PLANNING APPLICATION REPORT**REF NO:** FG/79/09/**LOCATION:** 58 Elm Park
Ferring**PROPOSAL:** Loft extension, replacement conservatory and garage extension (re-submission following previously approved FG/23/09)**SITE AND SURROUNDINGS**

DESCRIPTION OF APPLICATION	The proposed amendments increase the eaves of the property to approximately 3m high and the ridge height to approximately 7.3m high.
SITE AREA	Approximately 511 square metres.
RESIDENTIAL DEVELOPMENT DEN	N/A
TOPOGRAPHY	Predominantly flat
TREES	None of any significance affected by the proposed development.
BOUNDARY TREATMENT	Dwarf brick wall to the front of the property approximately 600mm high.
SITE CHARACTERISTICS	Detached single storey property. Red brick walls, hipped red tile roof with gable section. Flat roof garage to the side of the property. Open porch to the front of the property.
CHARACTER OF LOCALITY	The site is located within a cul-de-sac. Characterised by residential bungalows, many of which have been extended. Neighbouring property to the south has extensions to the rear and dormer window within the front elevation.

Proposed Plans and Section
Scheme 3

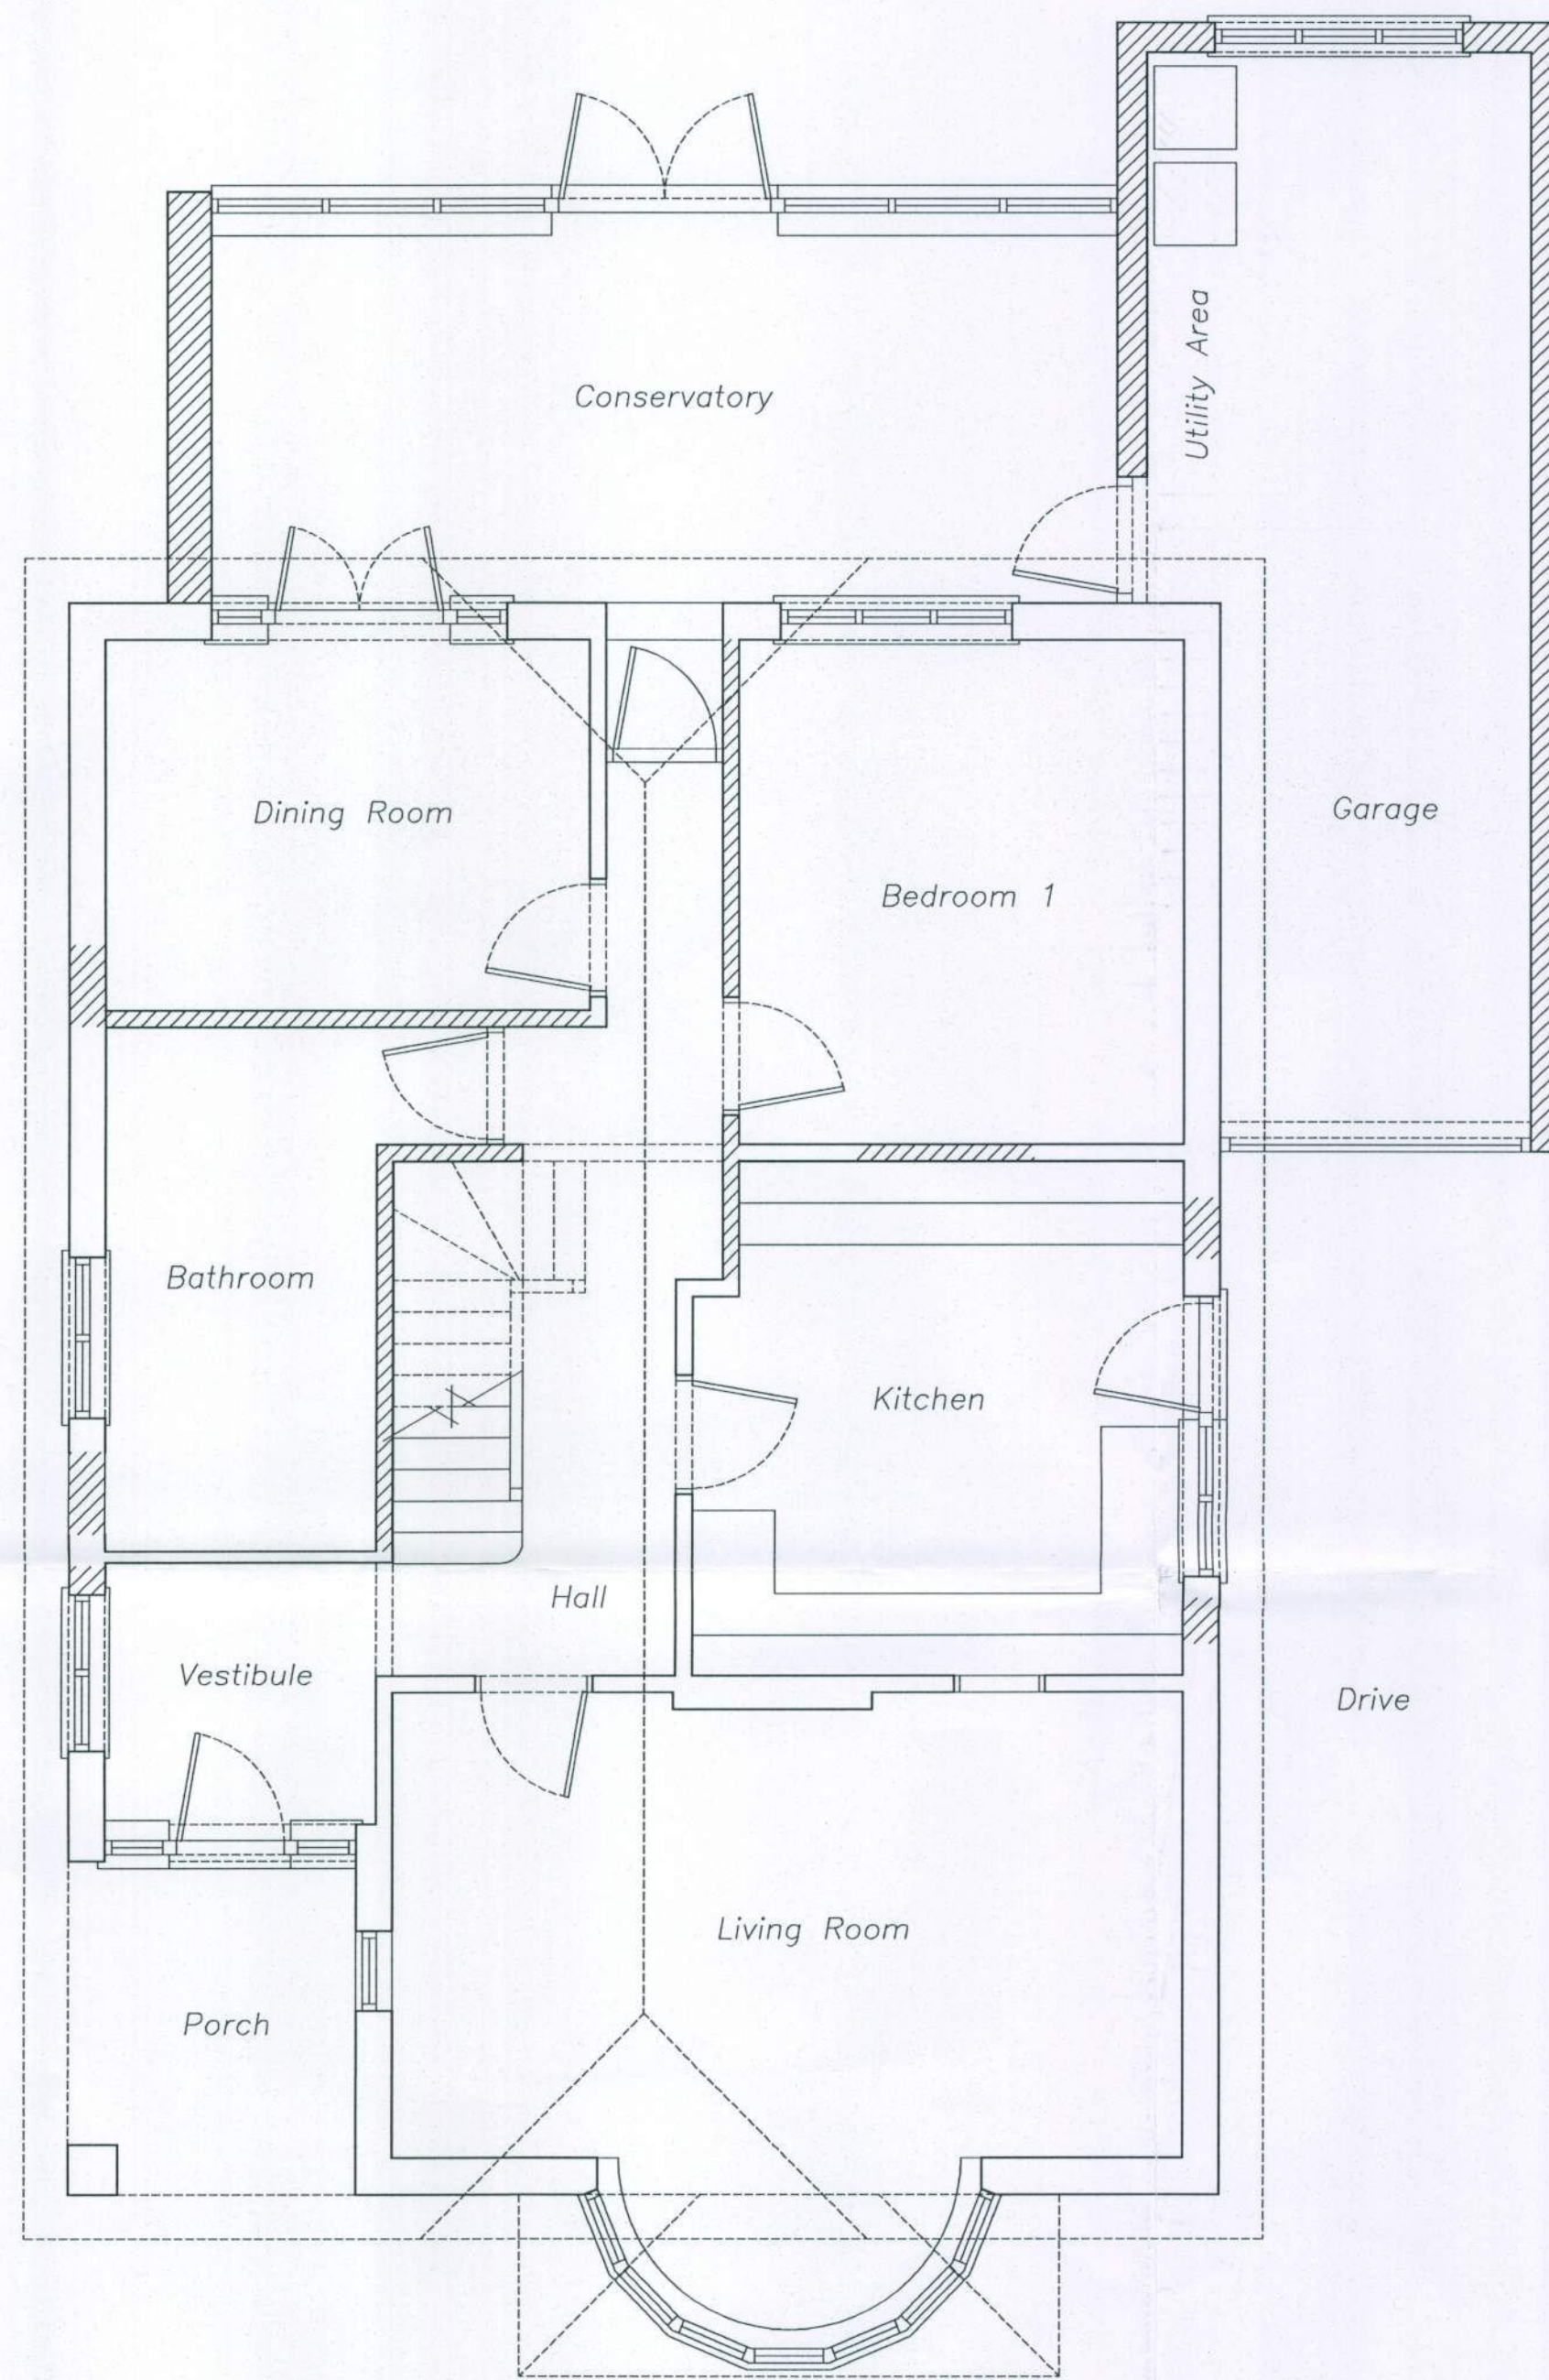
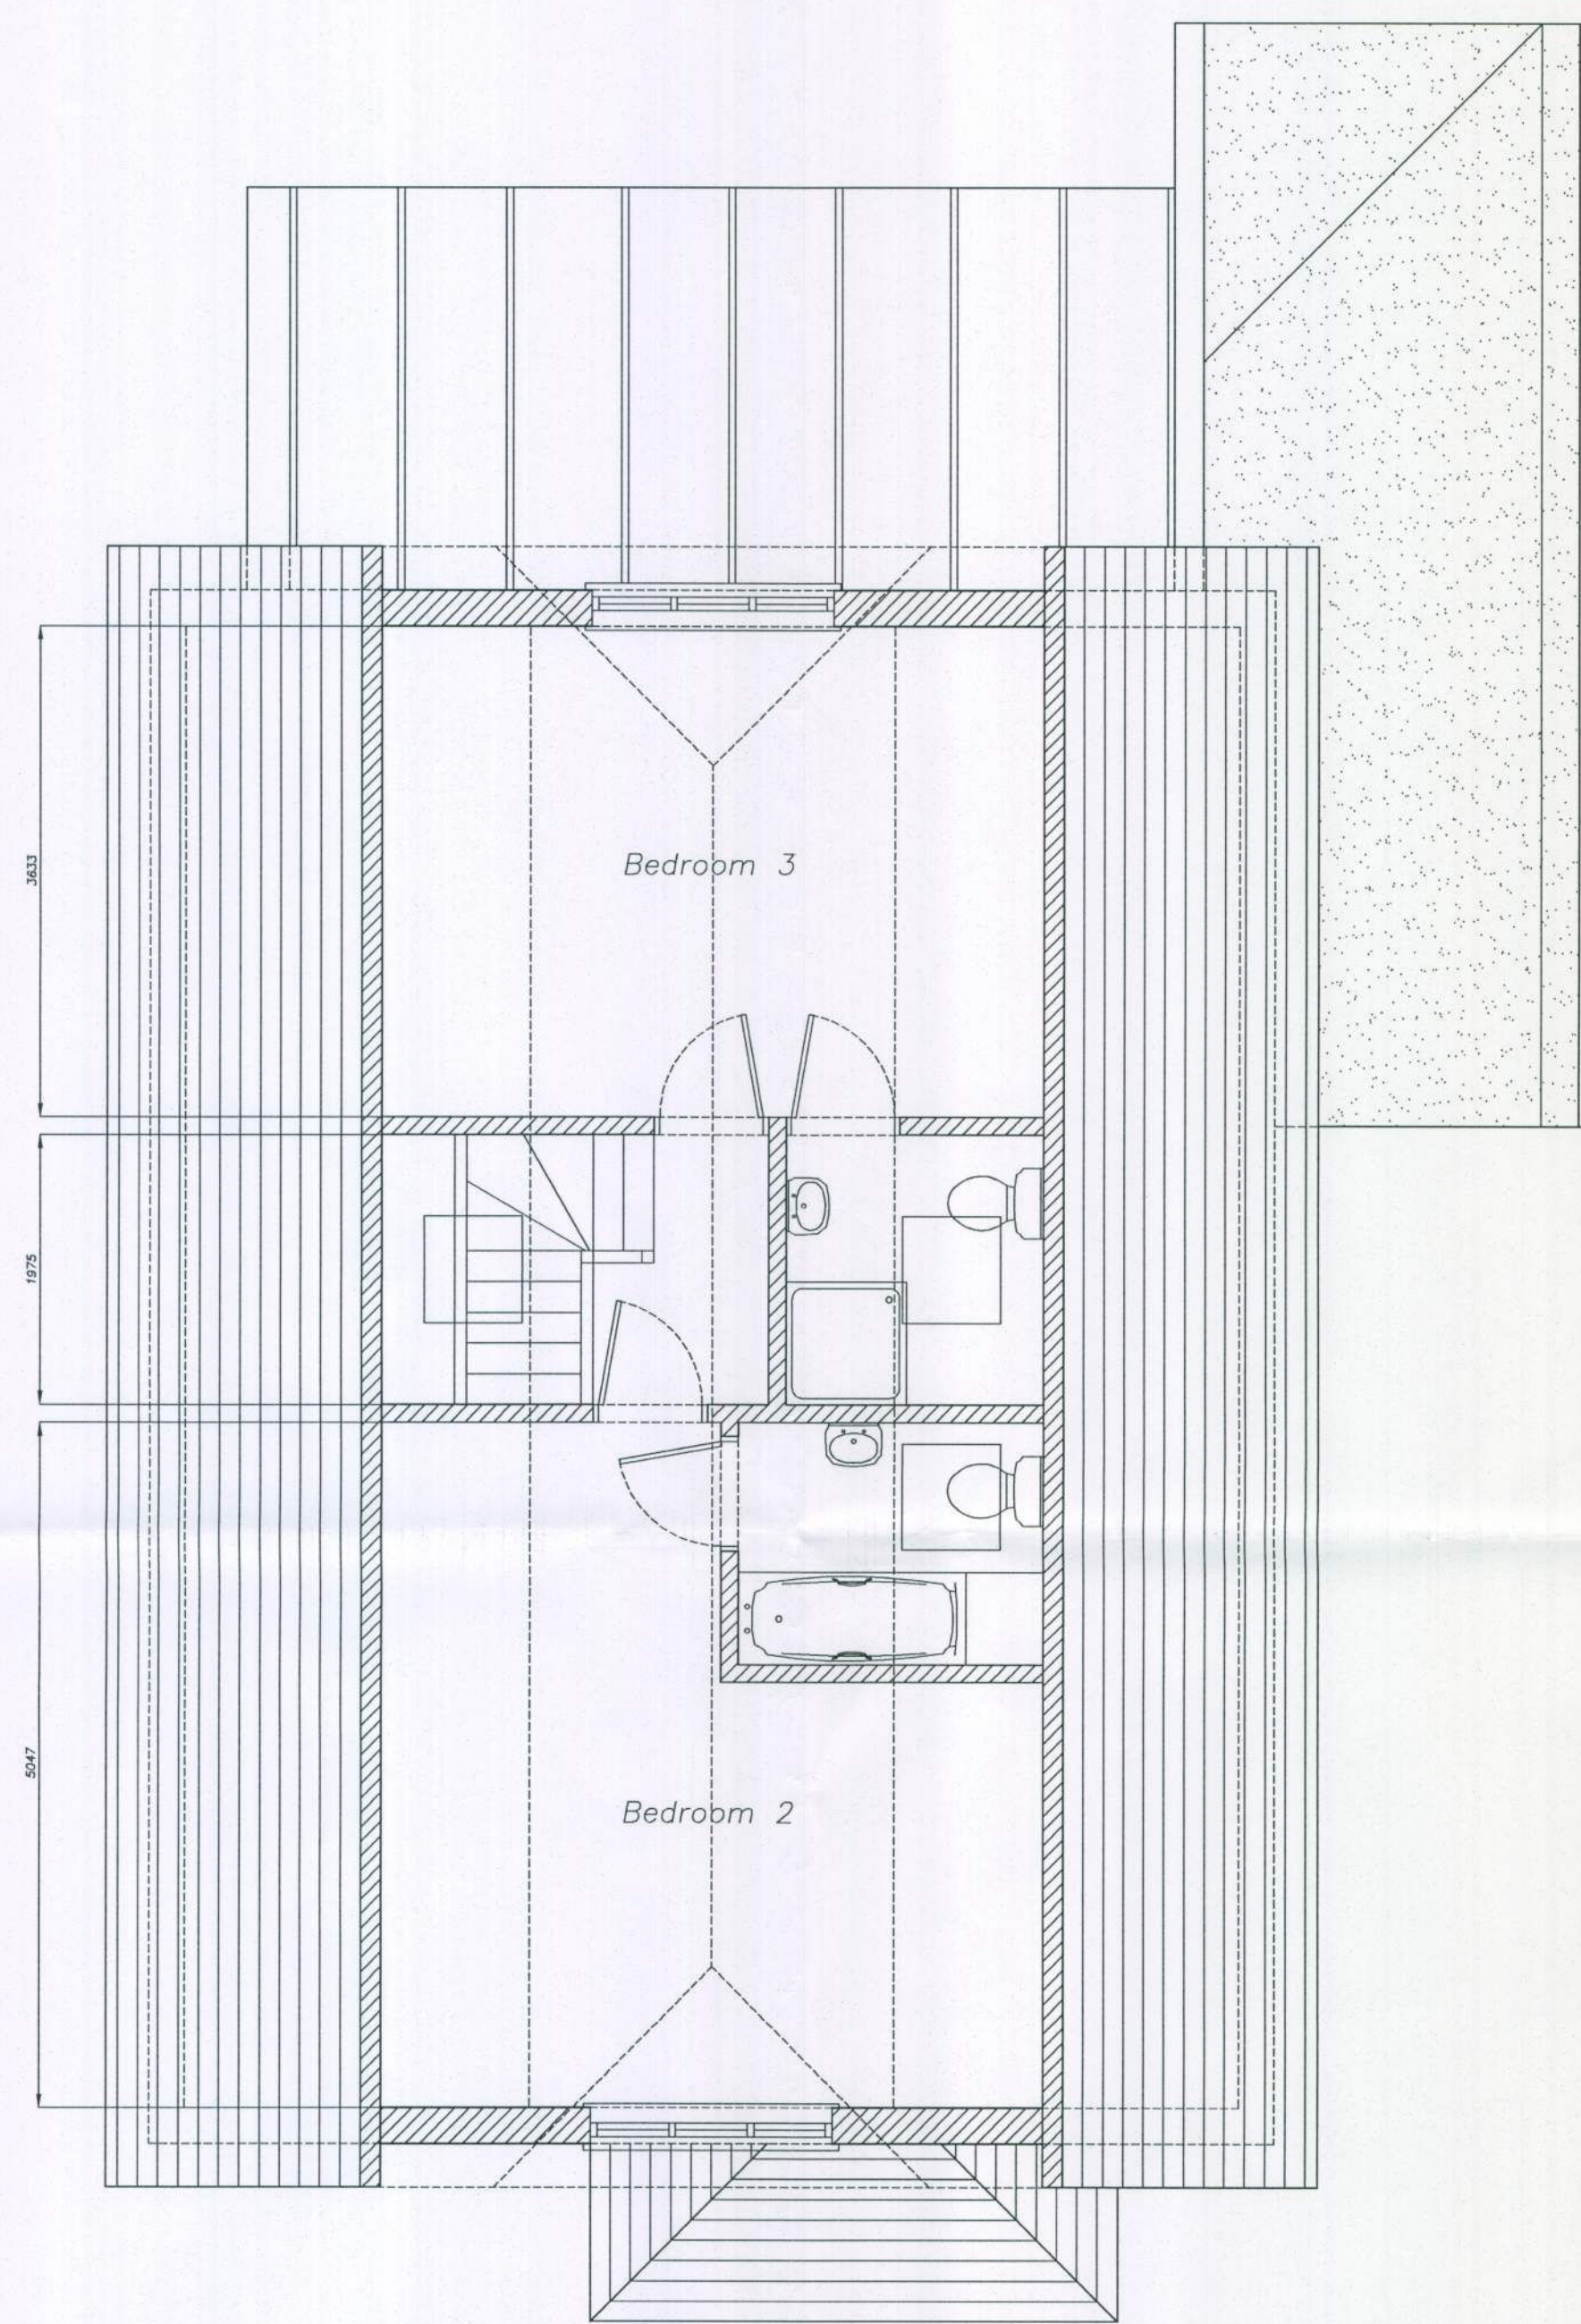
The proposed 1st floor fenestrations will face the front and rear of the property with only oblique

views available of the rear gardens of the neighbouring properties. The views from ground floor windows will be screened by the existing boundary treatment, therefore the development is not considered to result in demonstrable loss of amenity to the neighbouring properties by way of overlooking.
